CITY OF ALBUQUERQUE

RE: Element Hotel
2440 Louisiana Blvd. NE
Grading and Drainage Plan
Engineer's Stamp Date: 06/25/21
Hydrology File: H19D087

Based upon the information provided in your submittal received 07/16/2021, the Grading & Drainage Plan and Drainage Report **are not** approved for Building Permit and Grading Permit. The following comments need to be addressed for approval of the above referenced project:

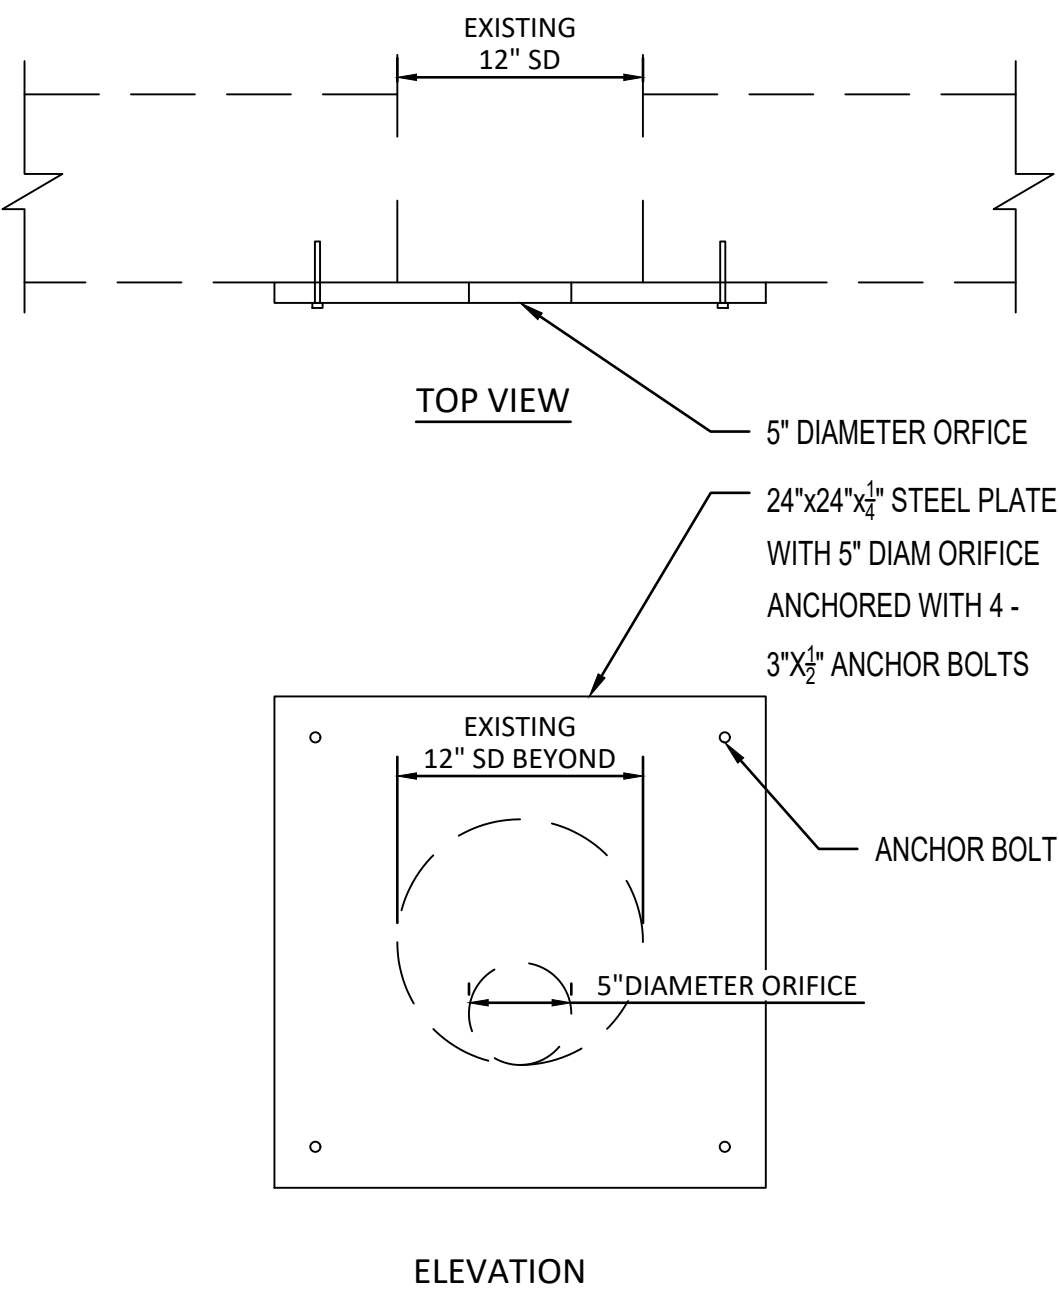
1. It is unclear what is being constructed and what is existing. In places the line work for the existing is the same line weight as proposed. There appears to be existing contour lines and proposed contour lines but again there is no clear what is what. Please clean this up.

2. Please show the edge of saw cut of the existing pavement and label along this, "Match existing grades". It is currently unclear where the area of construction is starting/stopping.

3. There also seems to be not enough proposed grade points to build this. I reviewed the approved Conceptual G&D and there were defiantly more points than this Grading Plan.

4. Please add the legal description of the adjacent property that contributes to the noted offsite flows.
5. Under the drainage calculations, please add some separation in the calculations. They almost seem to run on from the Stormwater Quality calculations to the underground retention calculations. It is a little hard to follow.

6. Please indicate on the Grading & Drainage Plan where the surface storage of 3,200 CF is being held.
7. Please indicate the location of the 5-in orifice located. Is it on the end cap of the underground chamber system? Or is it an orifice plate within the drop inlet?
